CITY OF ALBUQUERQUE

Re: Palomas Peak Ph. 2 Office Development
8300 Palomas Ave. NE
30-Day Temporary Certificate of Occupancy
Transportation Development Final Inspection
Engineer's Stamp dated 2-12-21 (D19-D031)
Certification dated 3-30-22

Subject: TCL Certification for D19D031

A1 SITE PLAN
1" = 20'-0"

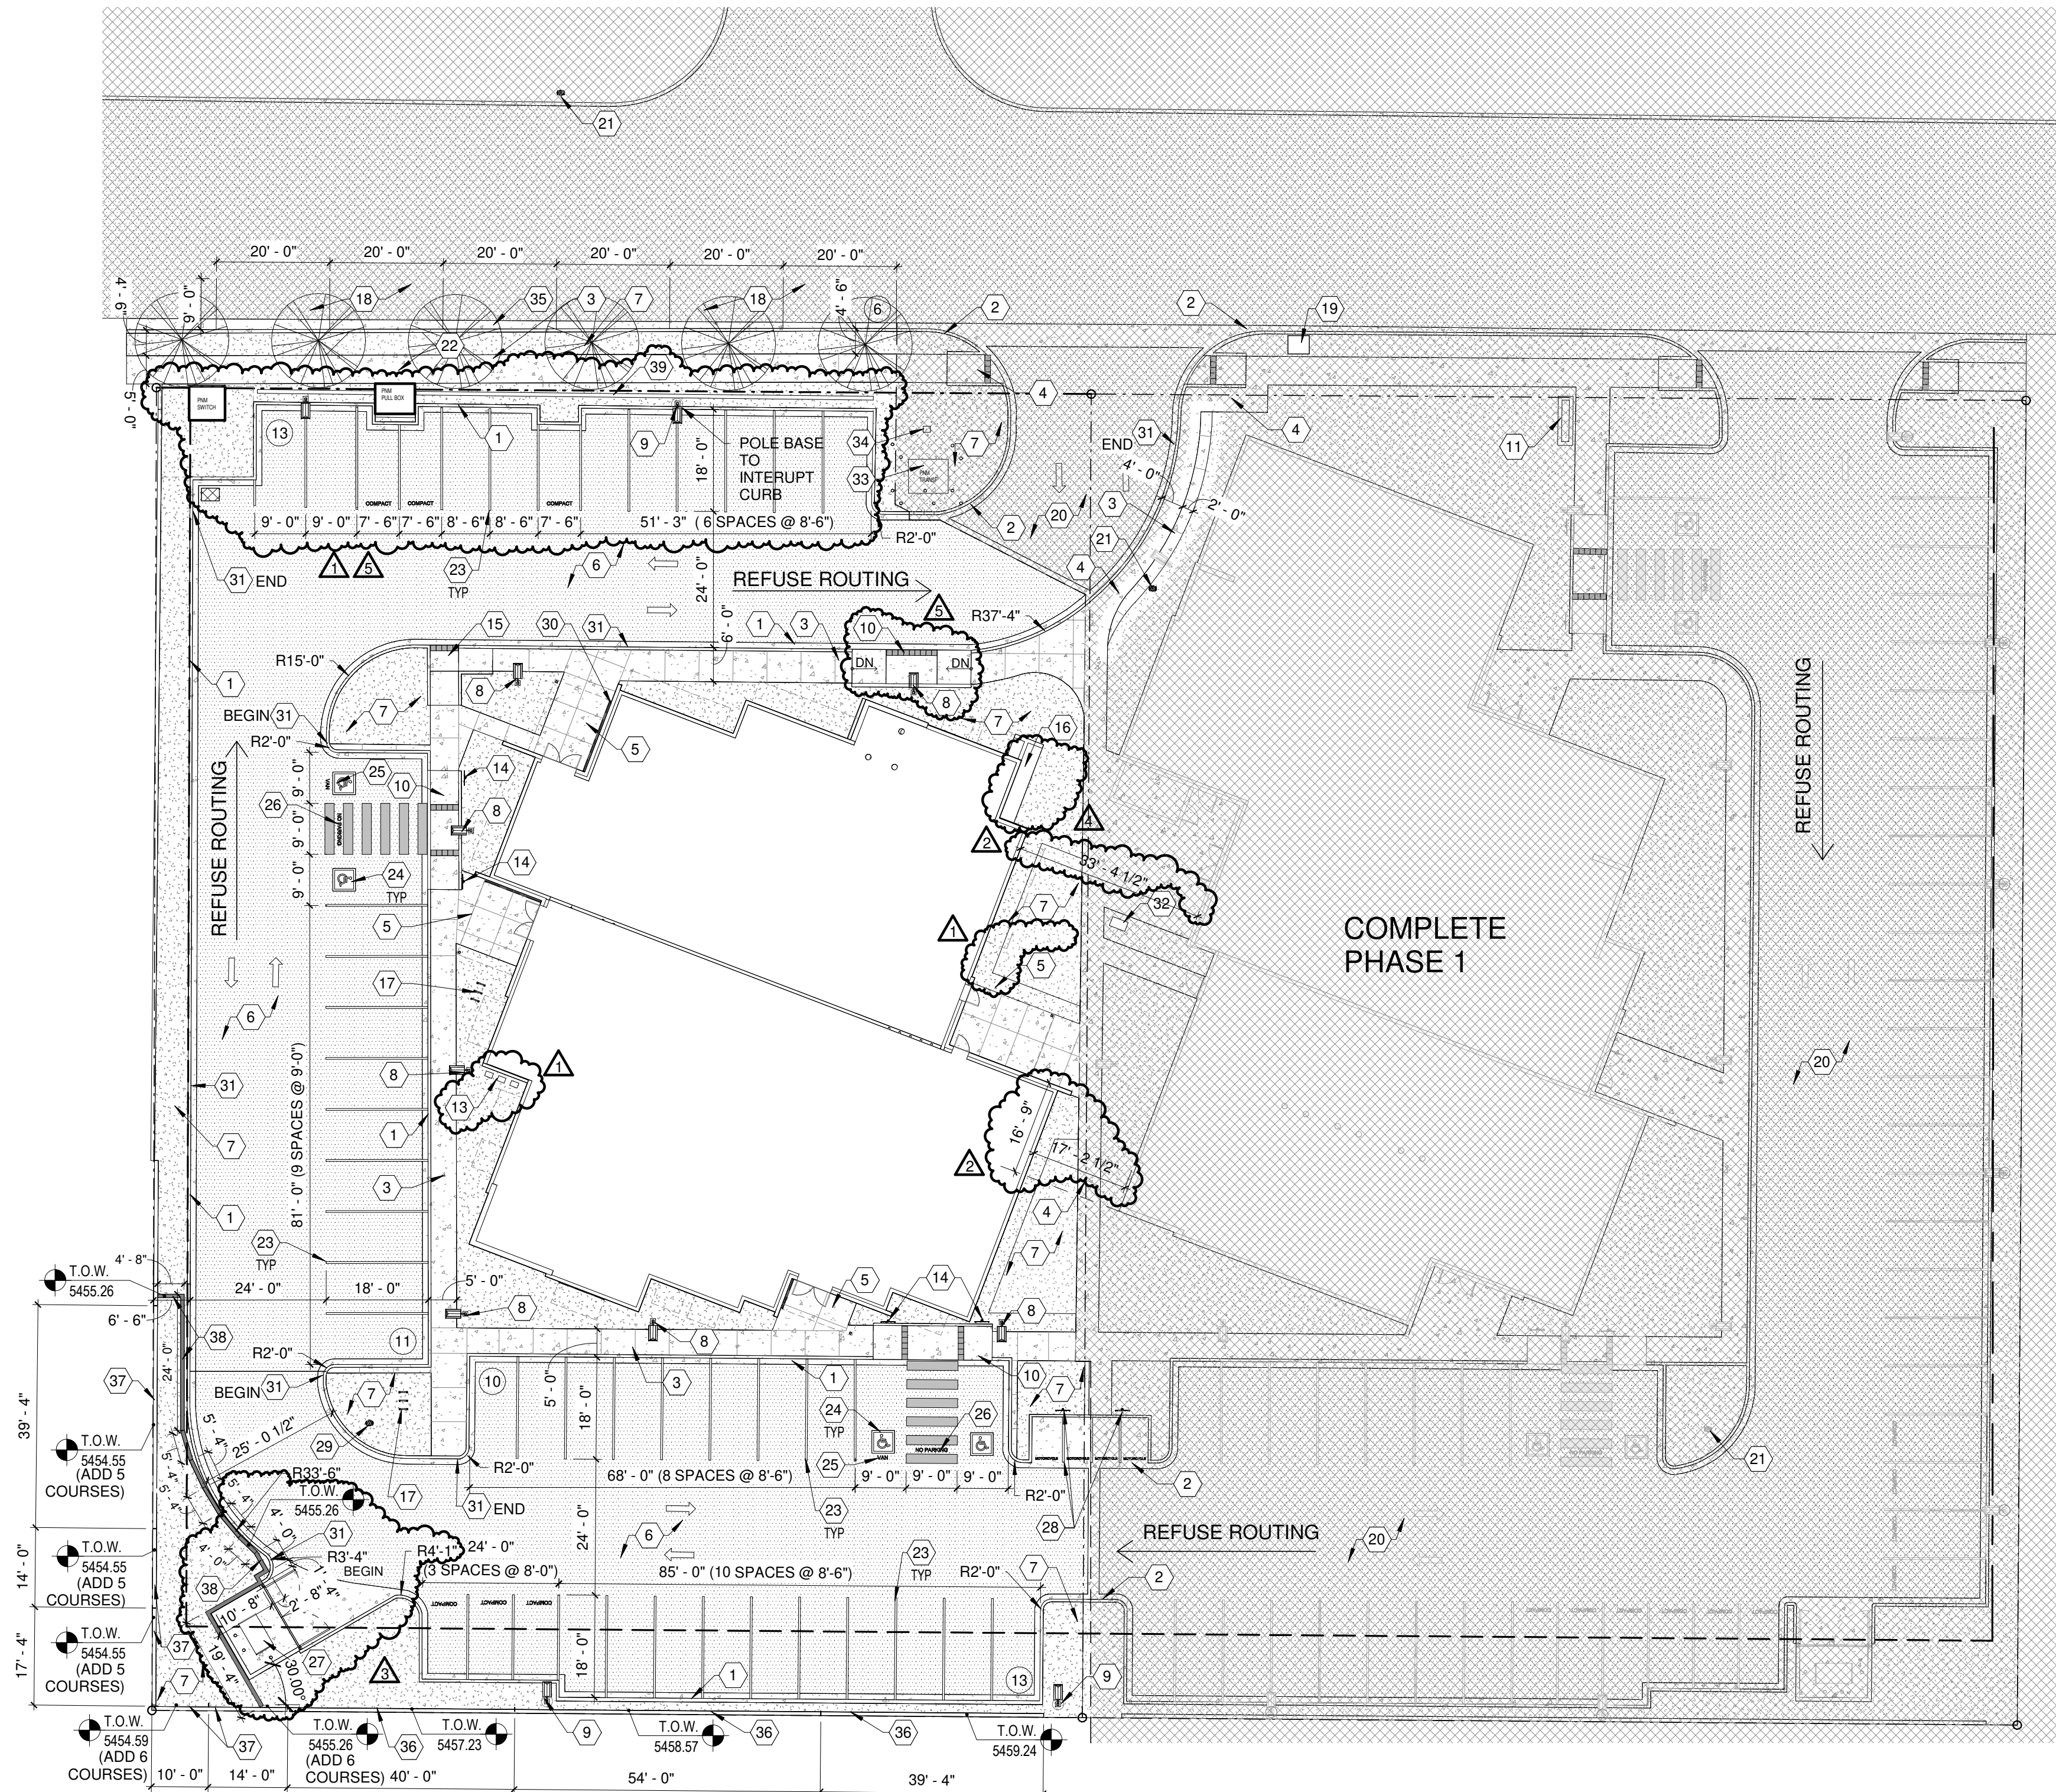
- There is a new ramp on the northside of the building, please red mark the approved TCL (add a key note for this ramp).
- Paint the curb that located at the northeast side of the driveway entrance with yellow. Just the segment that parallel with the ADA ramp, for tripping hazard issue.
